Our Ref: 20048269  
PINS Ref: EN010119  
Date: 23 July 2025  
Telephone: 03330 322546

**Planning Act 2008 – Application by North Falls Offshore Wind Farm Limited for an Order Granting Development Consent for the North Falls Offshore Windfarm (EN010119)**

I refer to the Rule 8 letter dated 4 February 2025 which sets out the Examination Timetable for the above Development Consent Order (DCO), currently at Examination. Essex County Council (ECC) in conjunction with Tendring District Council (TDC), and as described as The Councils, would like to provide a written response to the Applicant's submission at Deadline 07, as well as providing a closing statement.

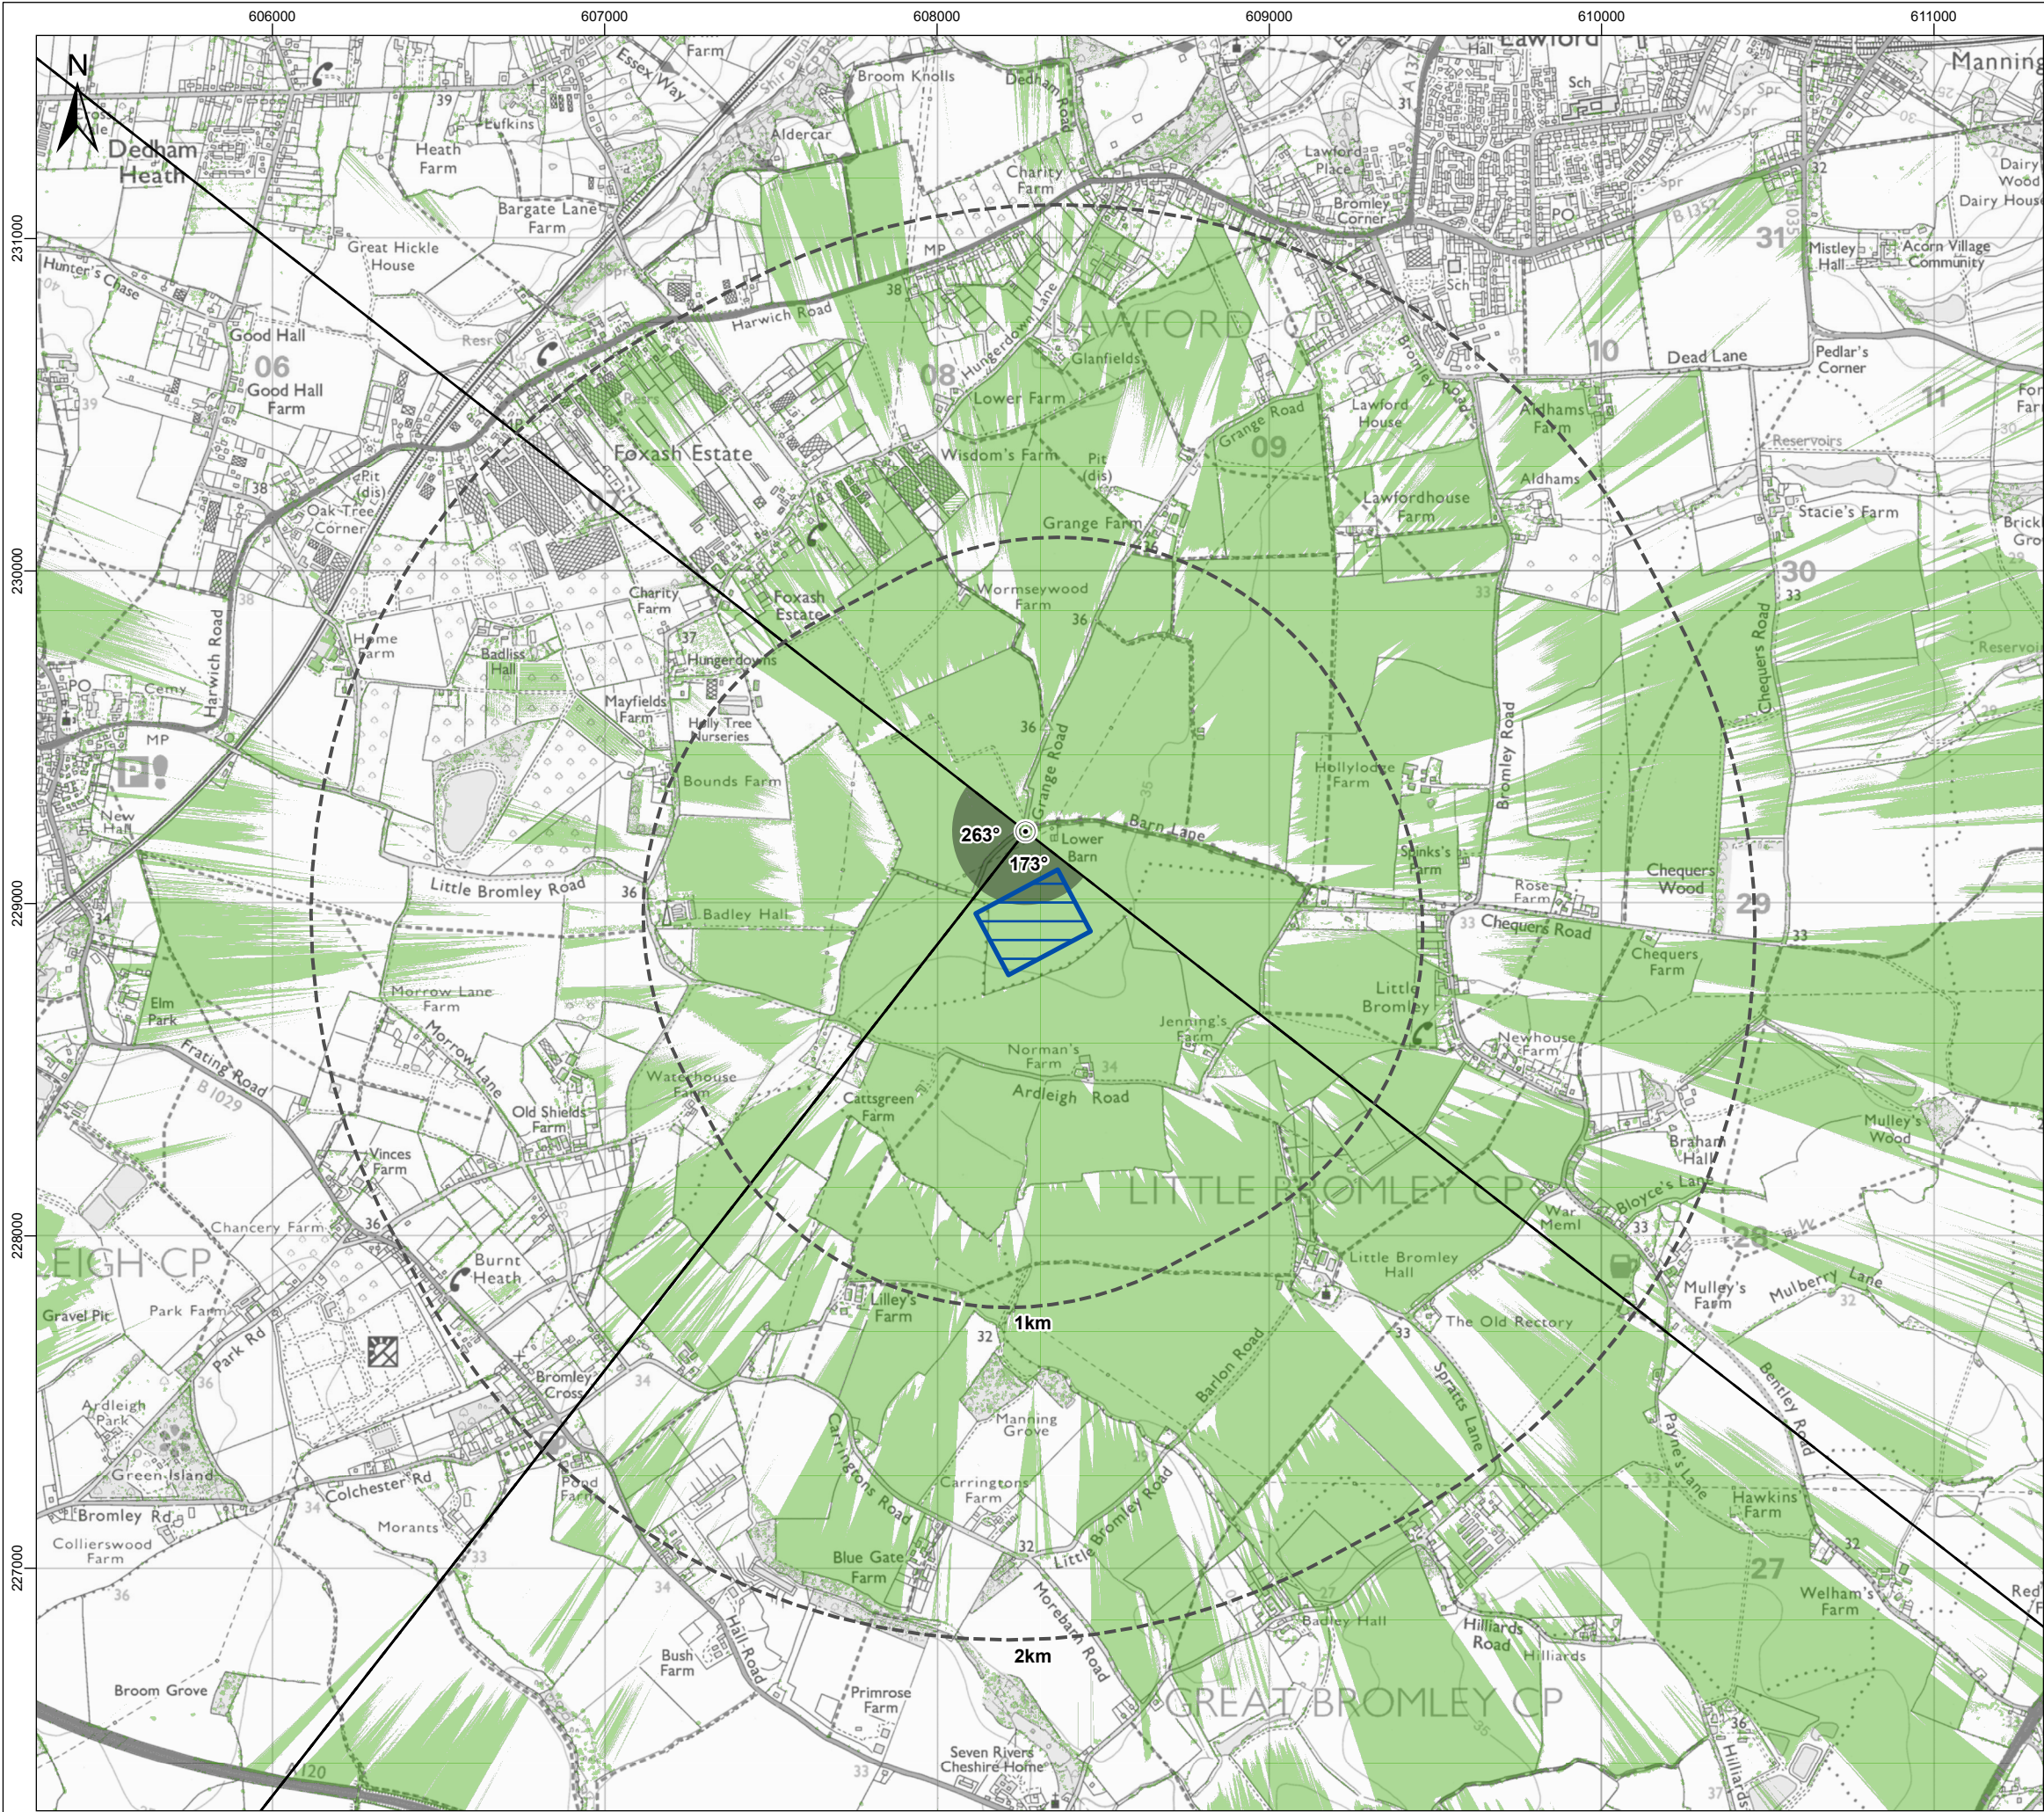
Item 6 Table 1: Sensitivity is not wholly dependent on designation and should not be presented in assessments as if it is.

Table 1 Construction and Operational impacts – acknowledges that impacts from this viewpoint are significant adverse from construction through to Year 15. This could also be true at other points along the PRoW as users move along it. This data therefore supplements that in the original LVIA and provides further justification for additional mitigation or compensation beyond the red line as advocated by the Design Council.
